M3 JUNCTION 9 NATIONALLY SIGNIFICANT INFRASTRUCTURE PROJECT

Written Summary of Oral Submissions

Issue Specific Hearings 1, 2 and 3

18 August 2023

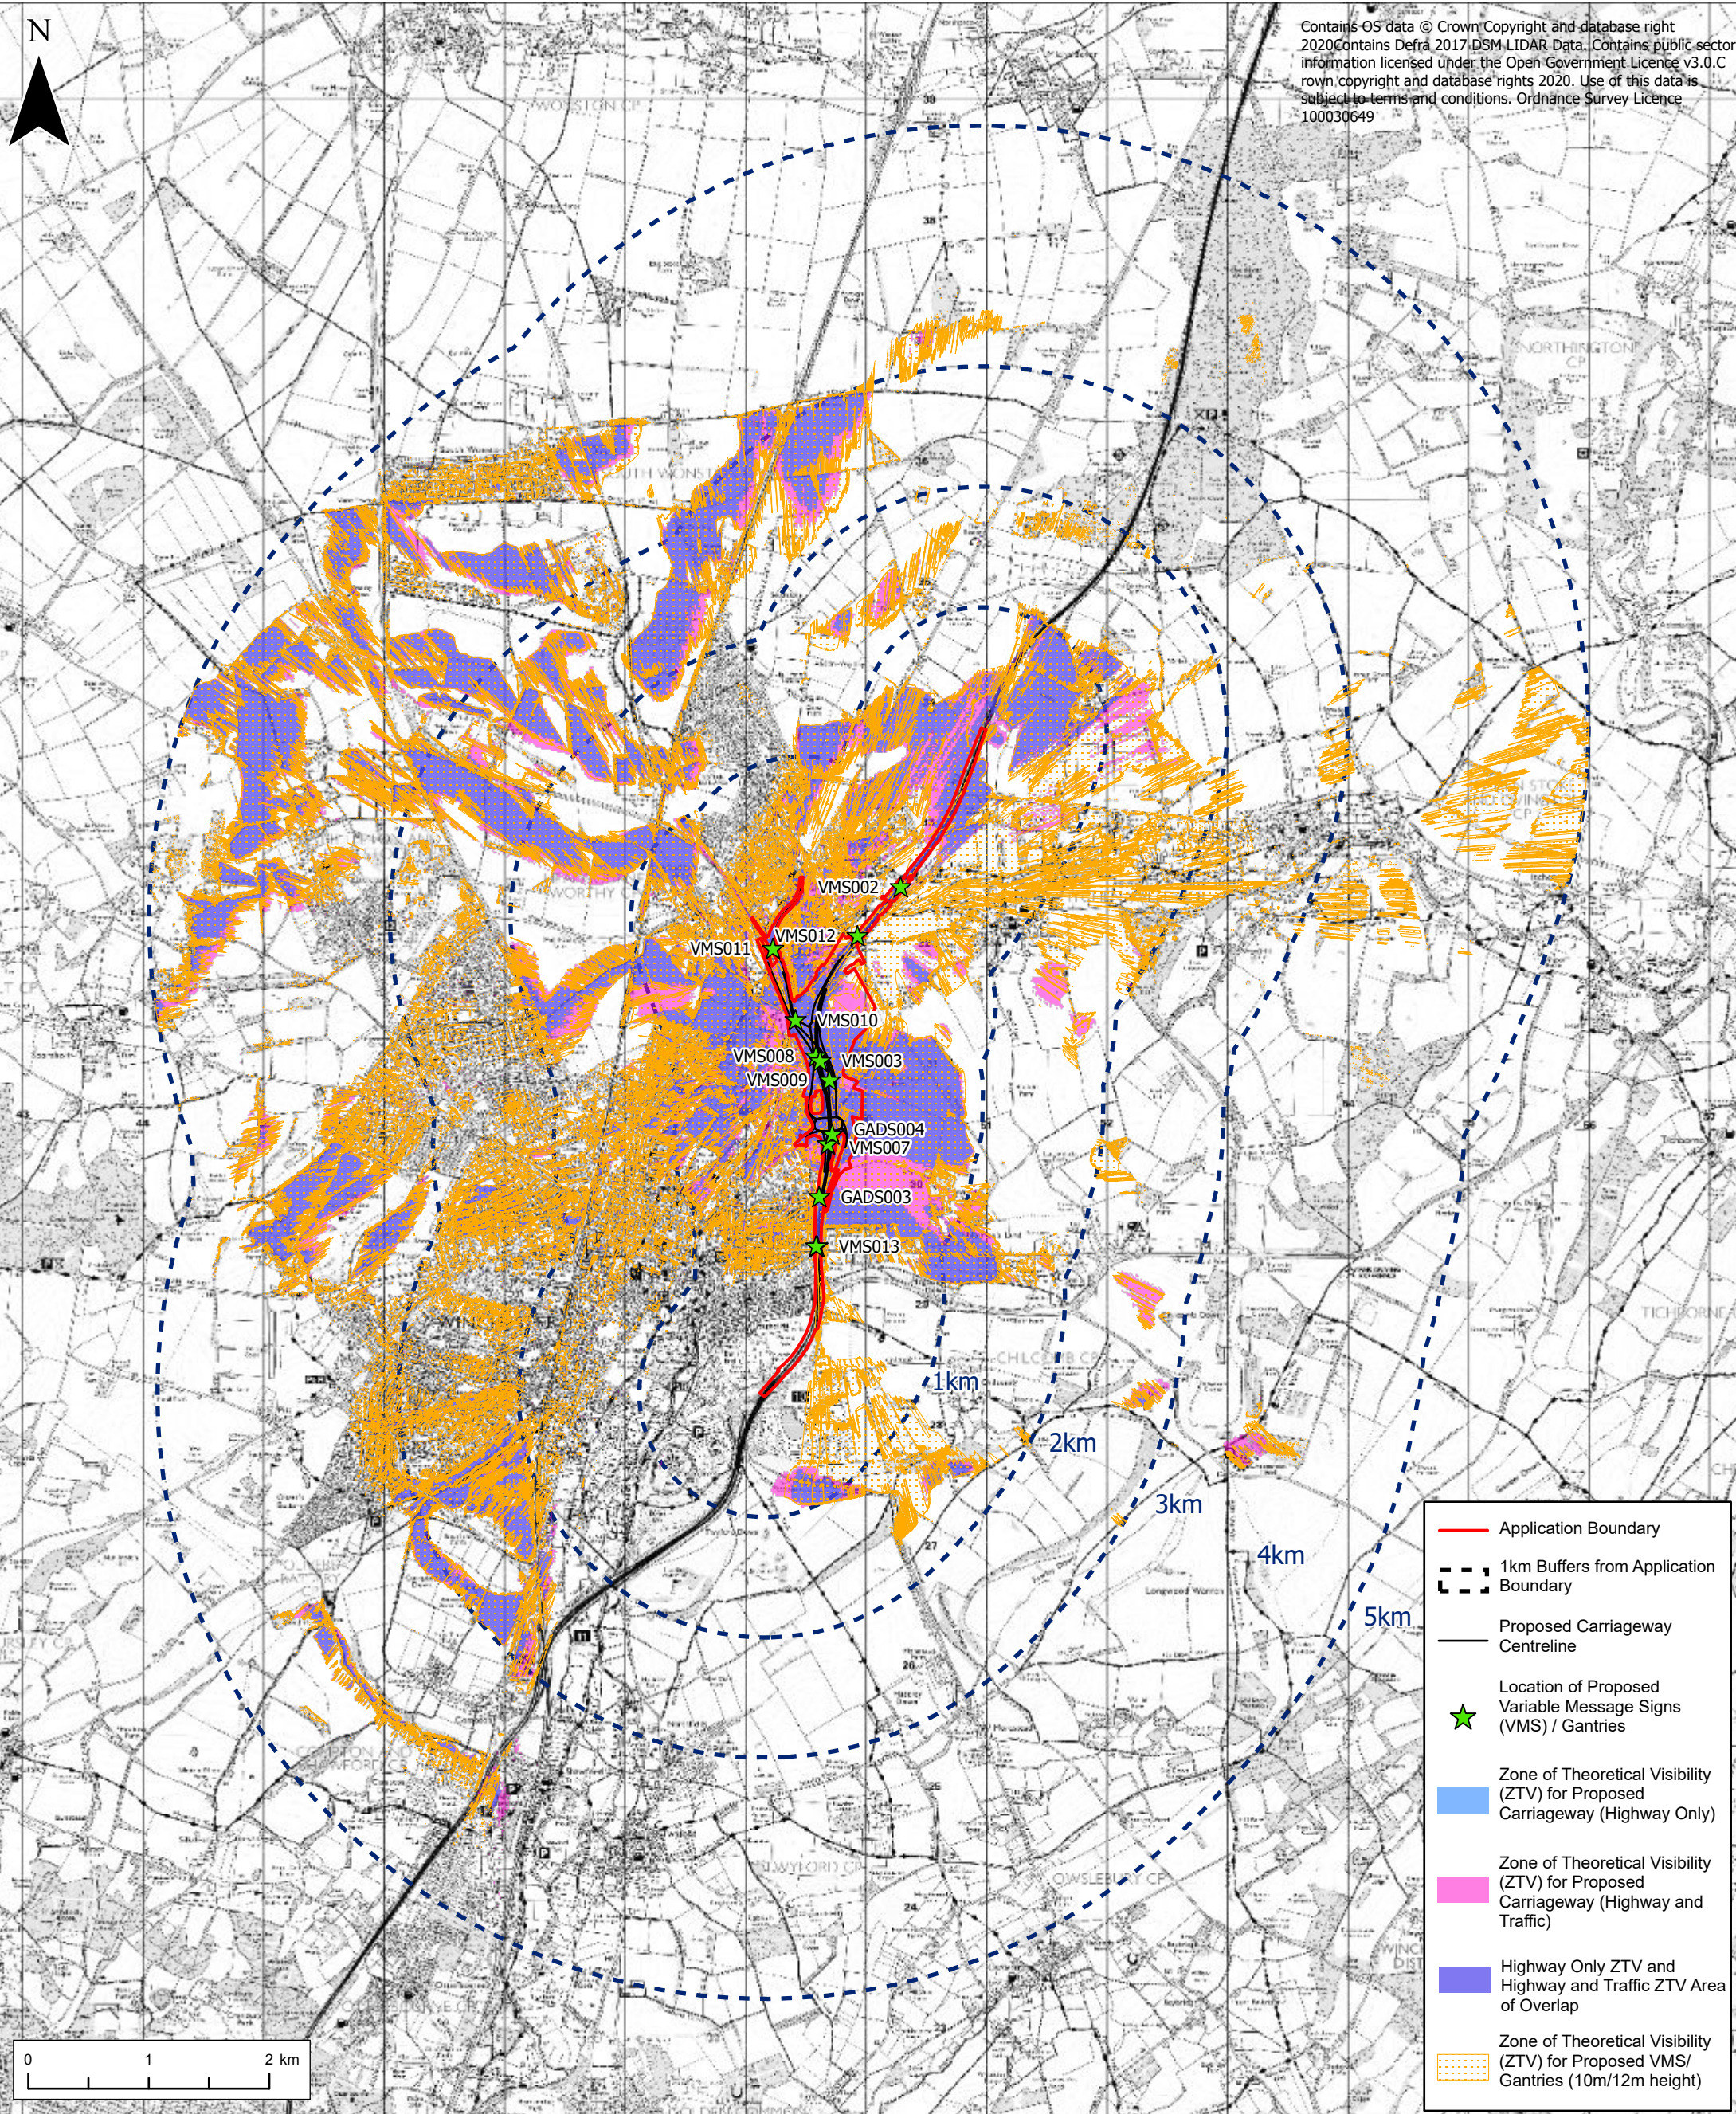
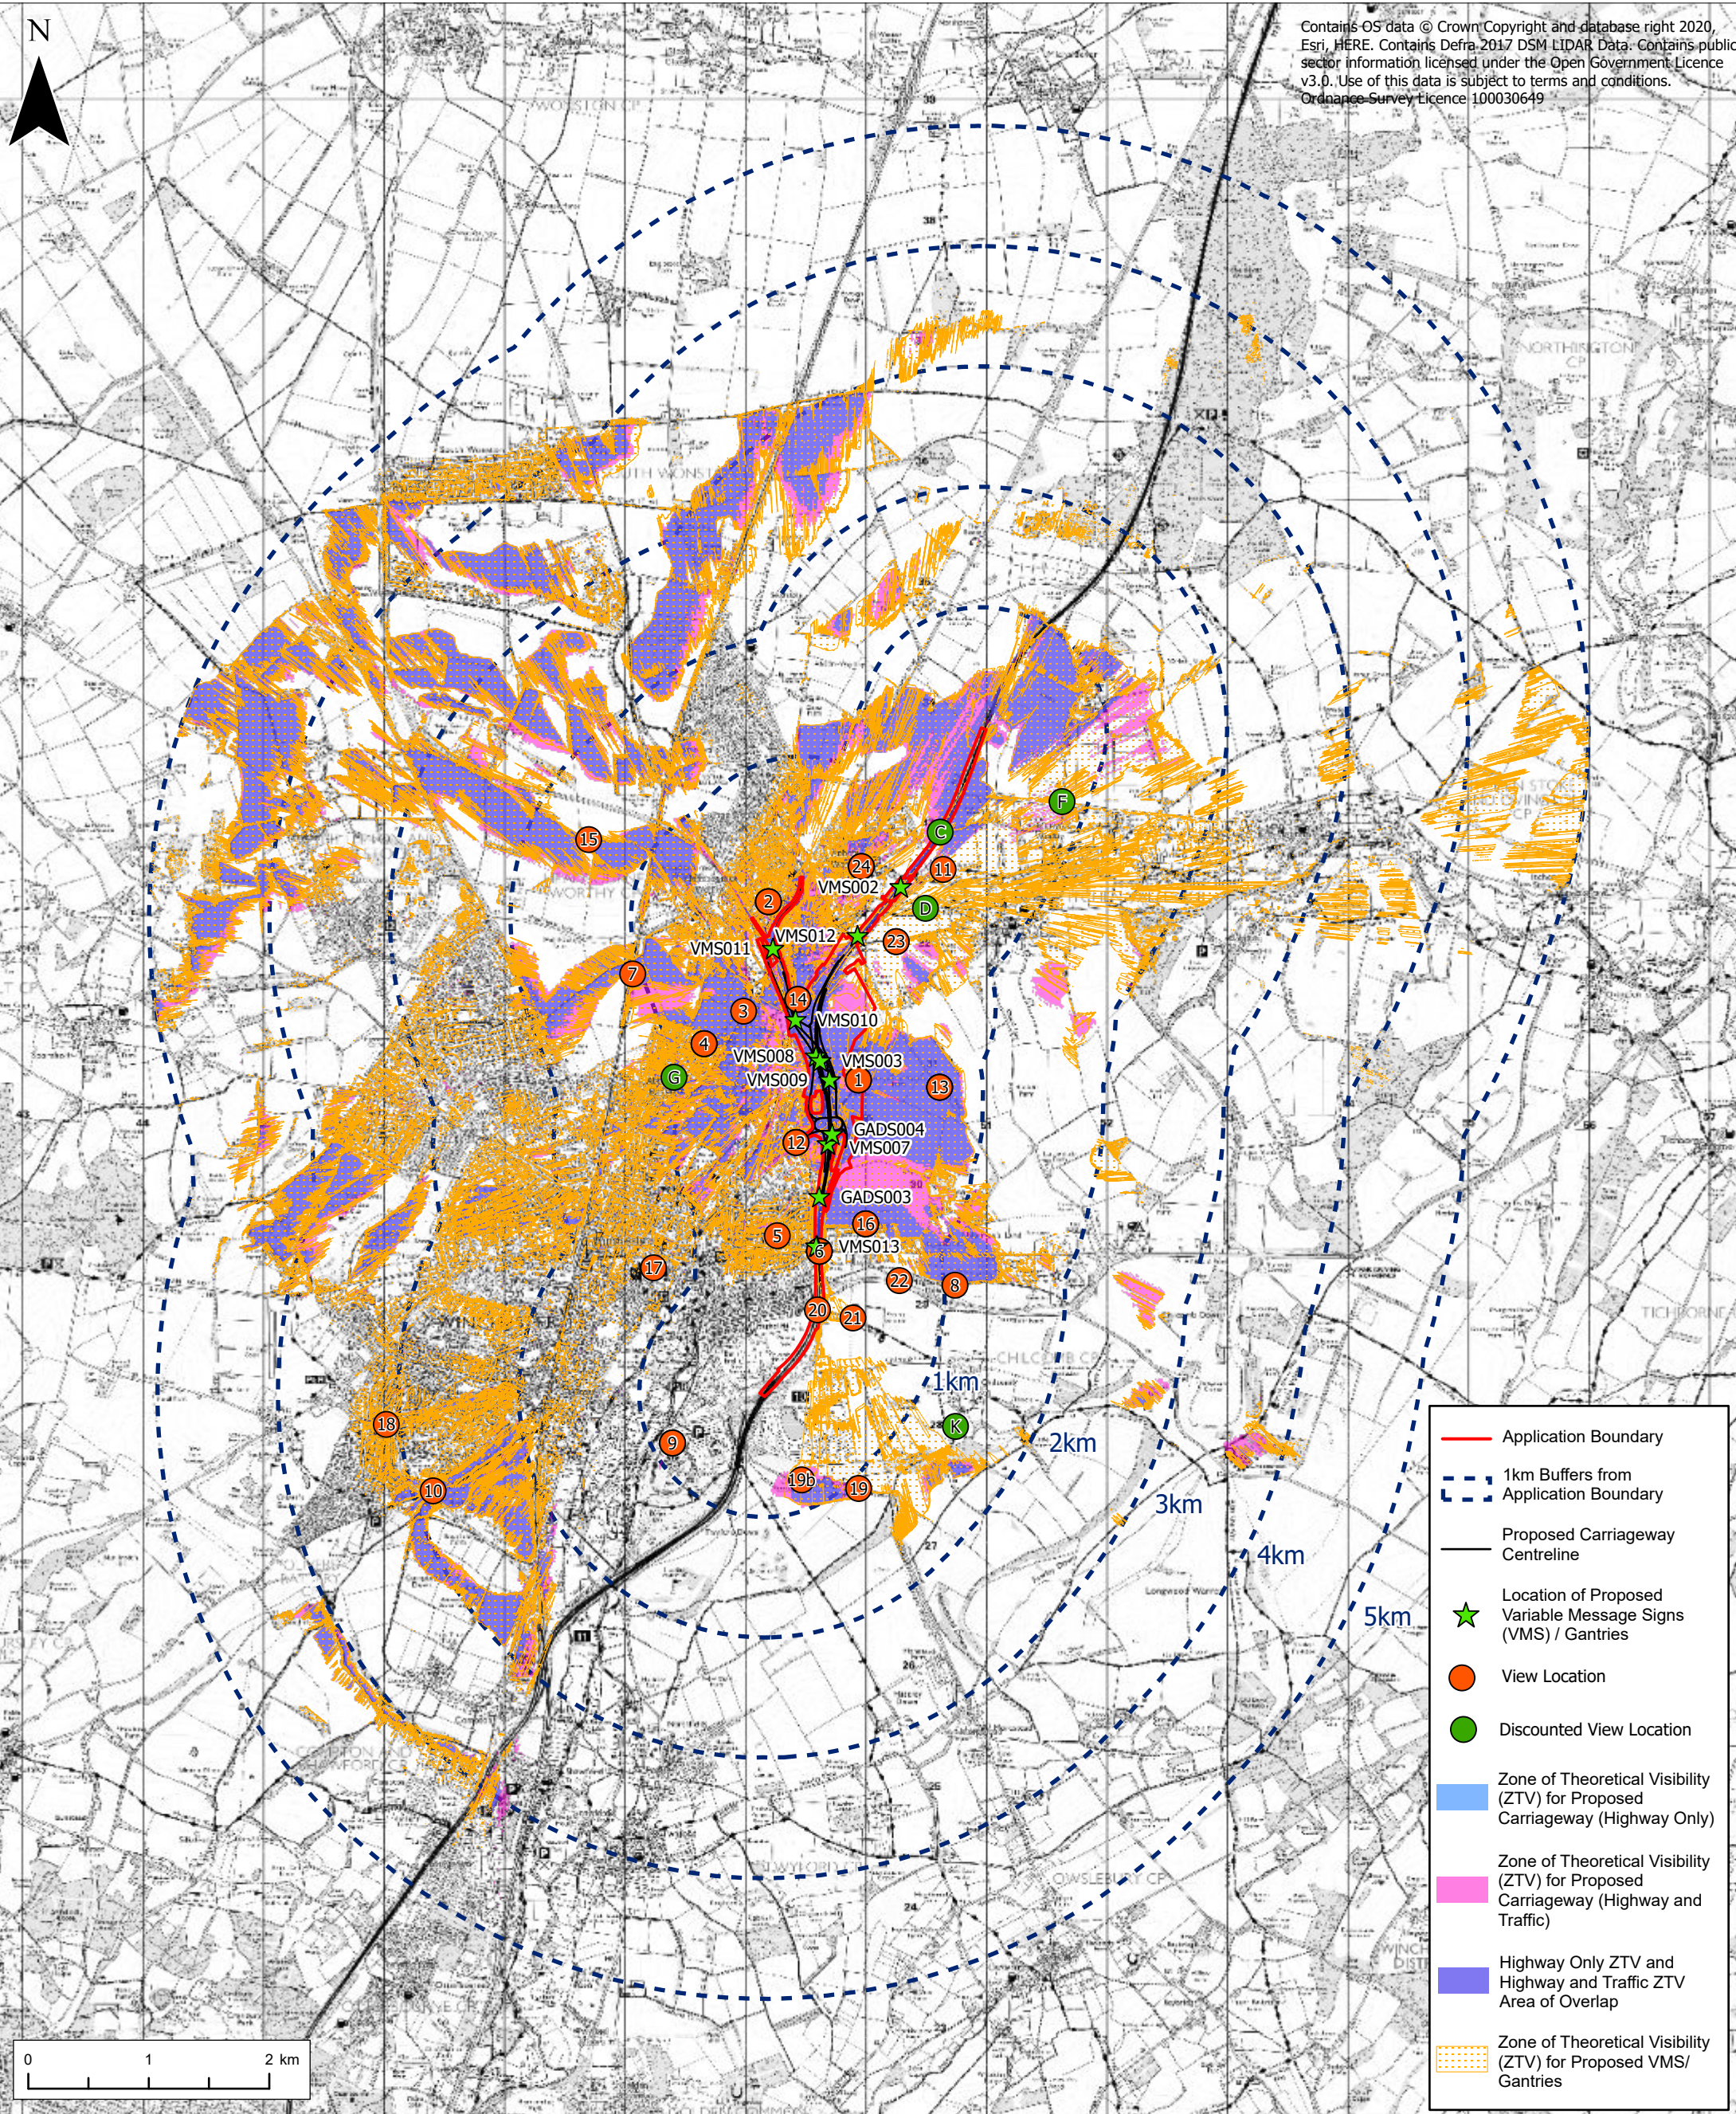
- Confirmation that there were no short-distance views of gantry signage, as only long-distance views had been provided (LIR 5.6.3)
- Reinstatement of the ground used for the temporary haul road (LIR 5.6.4)

The applicant has responded to these points to the satisfaction of the City Council. However, as the haul road is located within the National Park I defer to SDNPA officers on the reinstatement of the haul road.
